Your Ref: OWQC21194
Our Ref: EP/185/18/PL
Please ask for:
Mrs A Gardner

Demolition of existing buildings & erection of 3 No. dwellings with associated parking, alterations to existing access & relocation of staircase to flats (resubmission following EP/7/18/PL)..

Land rear of Beechlands Cottages Beechlands Close East Preston

Thank you for your internet comments made on 22nd January 2019 which has been recorded as **'an objection'** with the comments as follows:

DRAWING TITLE
Proposed Floor Plans and Elevations

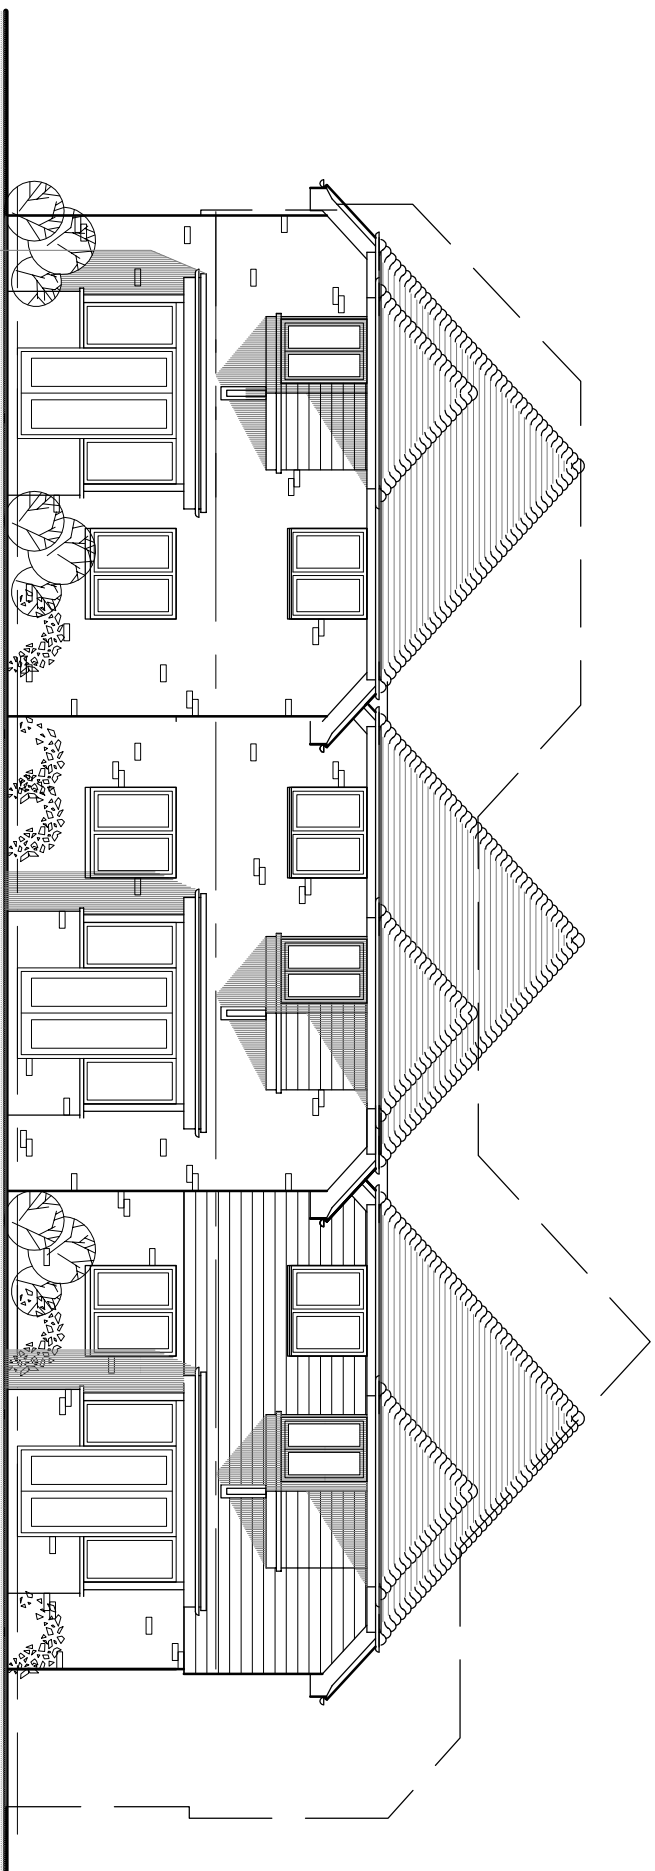
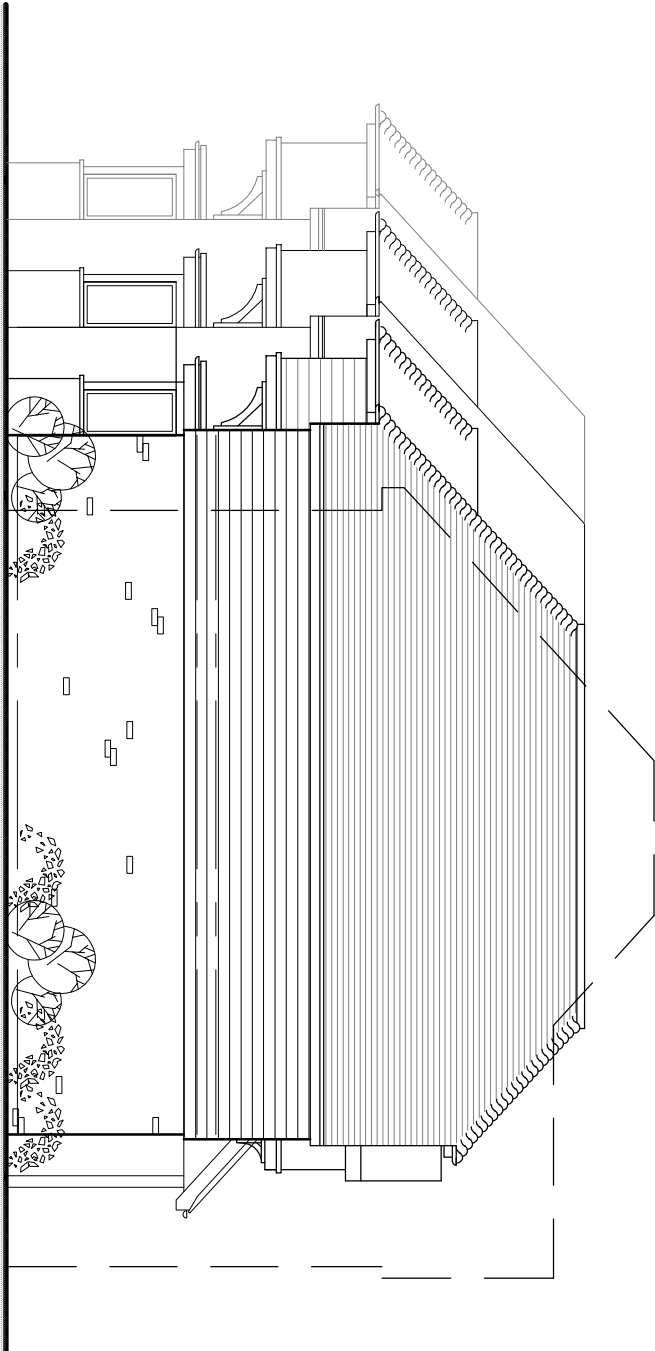
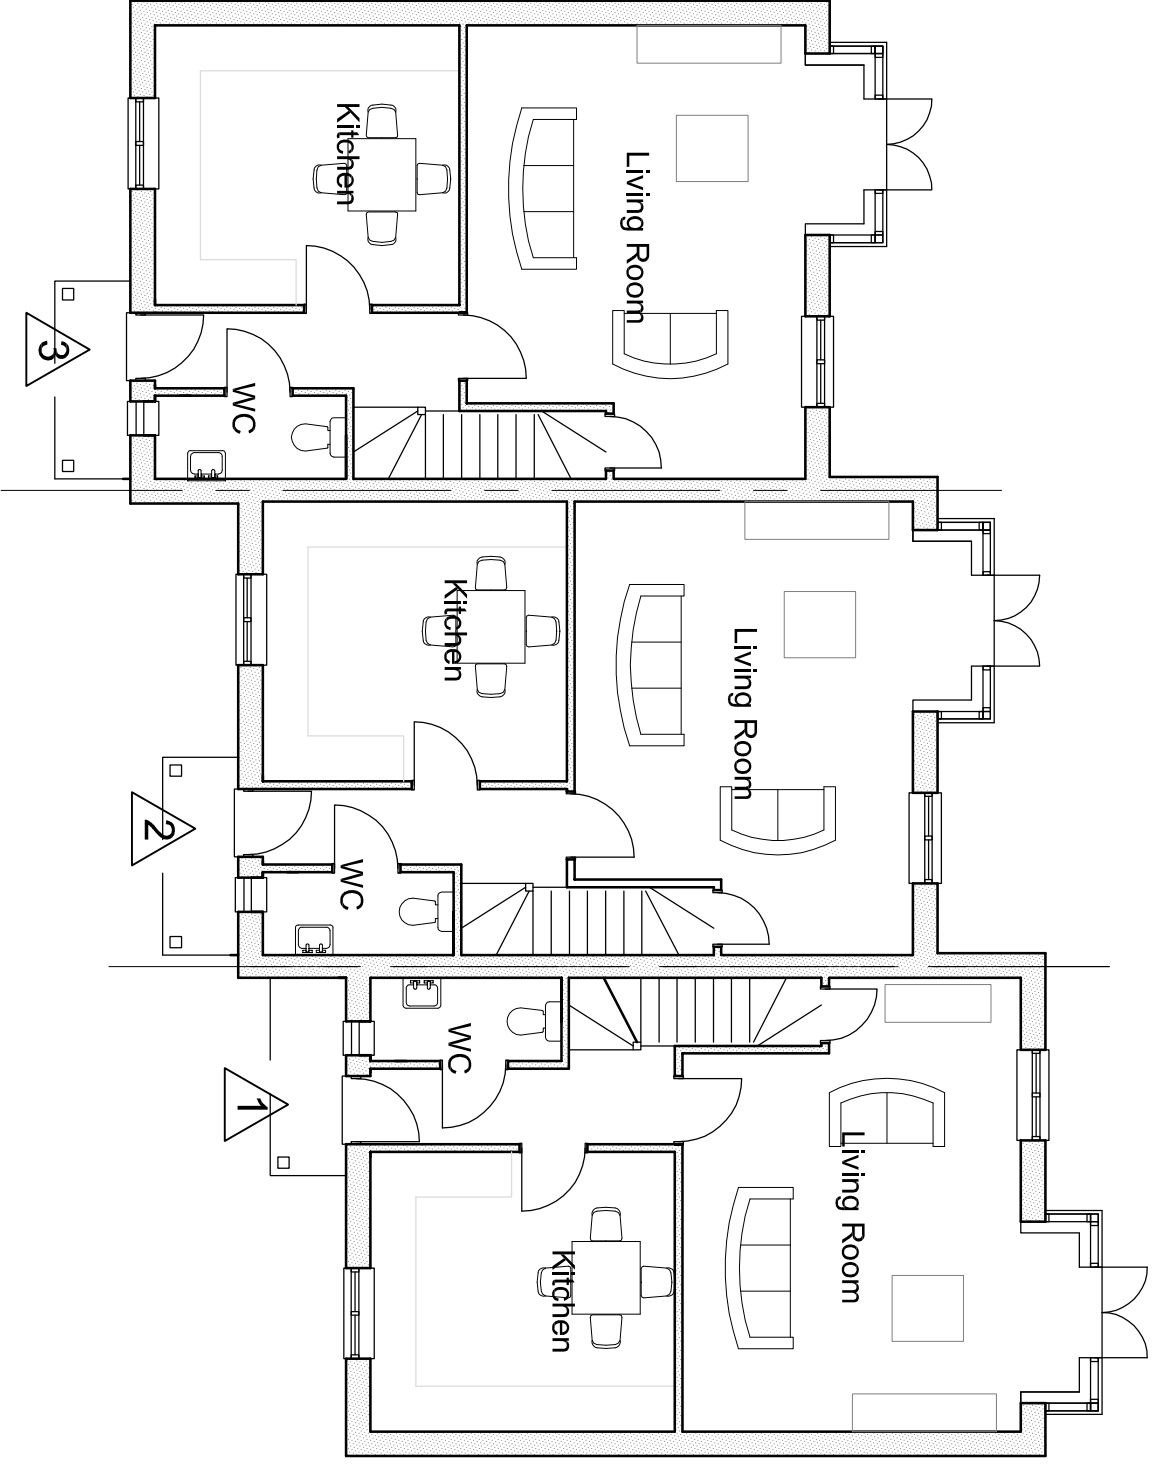
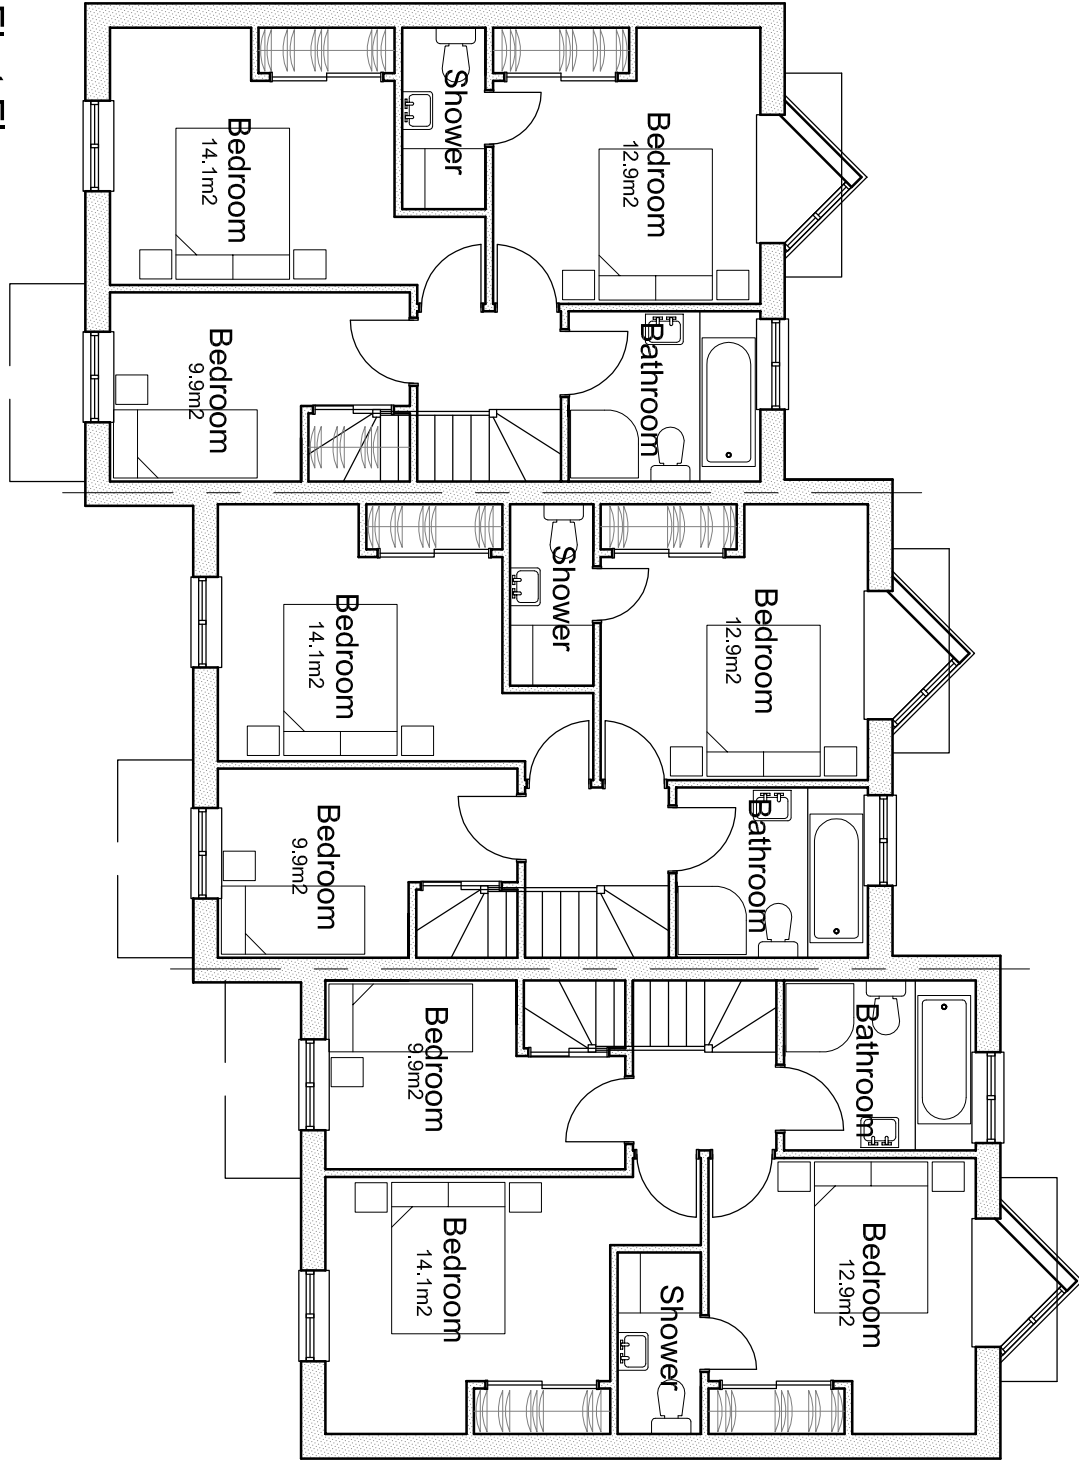
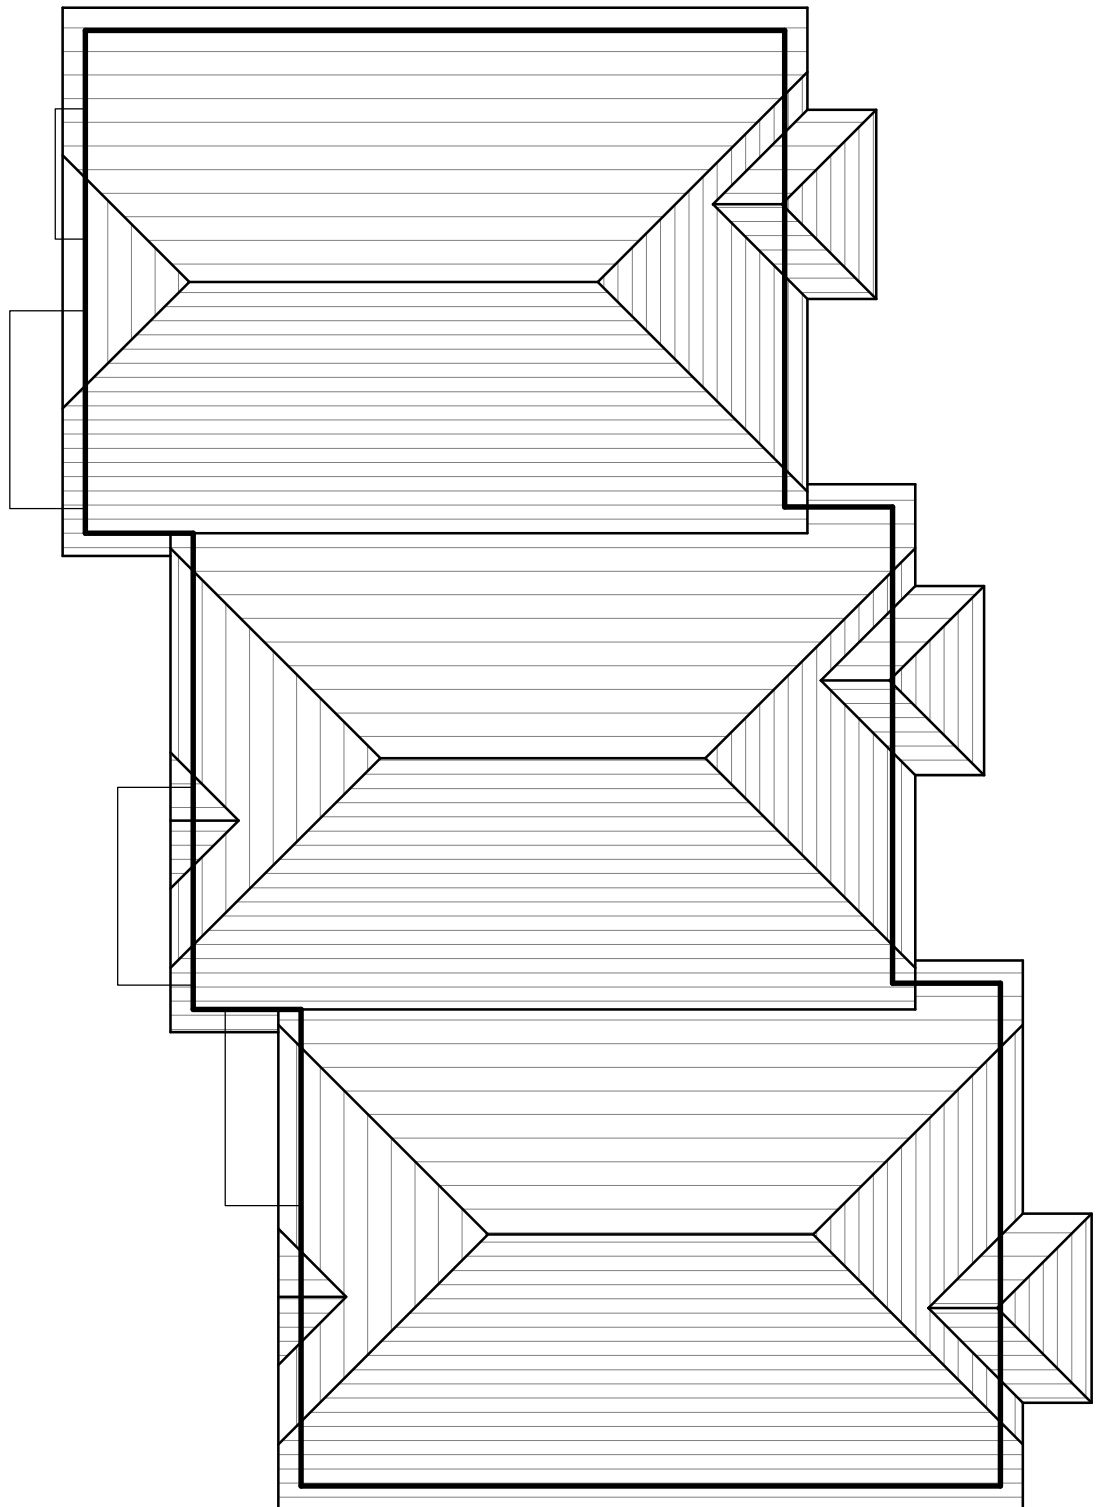
The proposed development would represent an overdevelopment of the site which would appear unduly cramped and would therefore be contrary to policies within the Arun District Local Plan, Policies 1 and 2 of the East Preston Neighbourhood Plan and the National Planning Policy Framework (NPPF).

The committee felt the design of the building was contrary to the National Planning Policy Framework though better than the previous two iterations, the design still feels slightly awkward and not in keeping with nearby properties. Section 64 of the NPPF states

Two properties are proposed to have fibre cement clapping. This is not vernacular for the village and is therefore out-of-keeping despite other new properties nearby having been allowed clapping.

The committee appreciated the plan moved the new properties further away from Nos. 1-4 Beechlands Cottages but closer to No. 125 North Lane. This could result in a loss of amenity.

DRAWING TITLE		
Partial elevations of existing building showing proposed new stairs

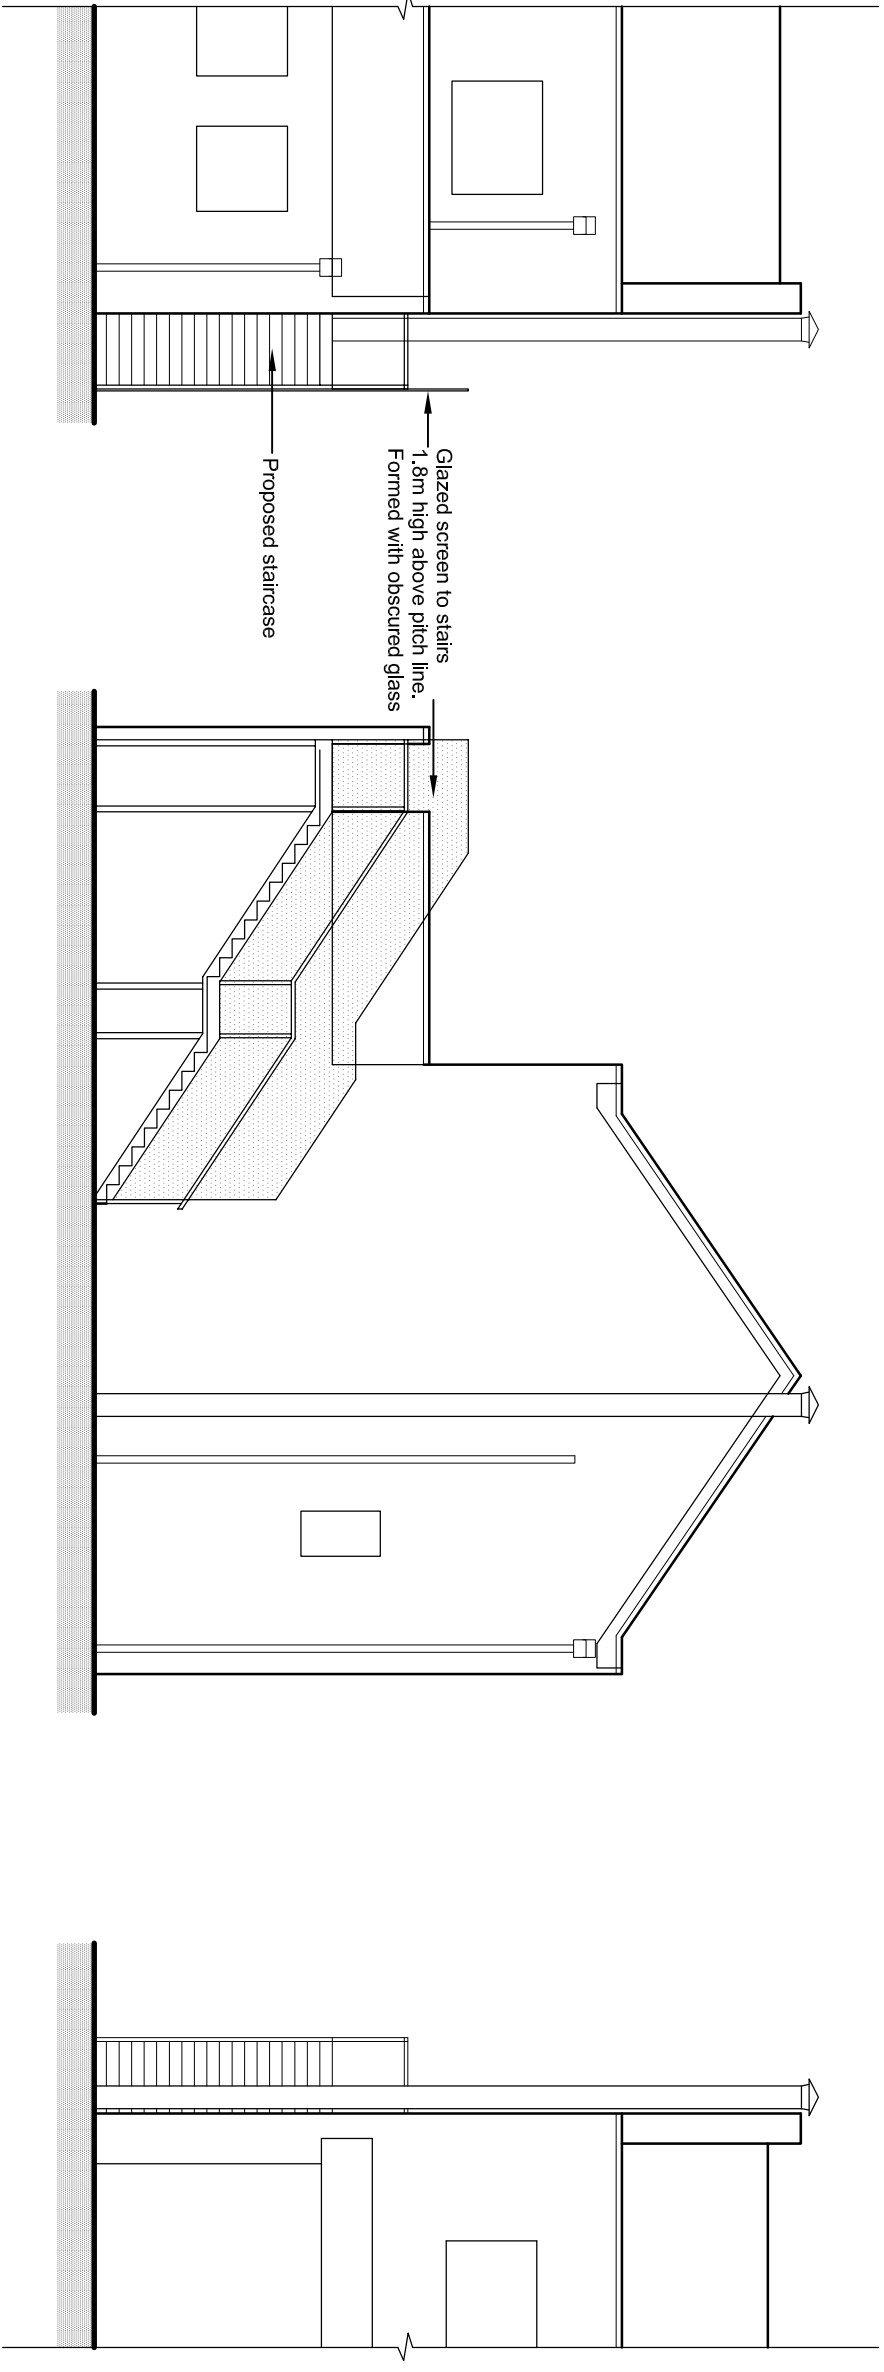
The committee remained concerned about the ability for emergency vehicles to access the site, not only the proposed new properties but also the rear of the existing flats above the shops in North Lane/Sea Road. The committee was concerned about emergency exit for the residents of the flats above these shops if the escape staircase is moved to one end of the building this will be an unnecessarily long route for some residents. The northern location of the fire escape will also see it overlooking the garden of No. 125 North Lane and will result in a loss of privacy to that property.
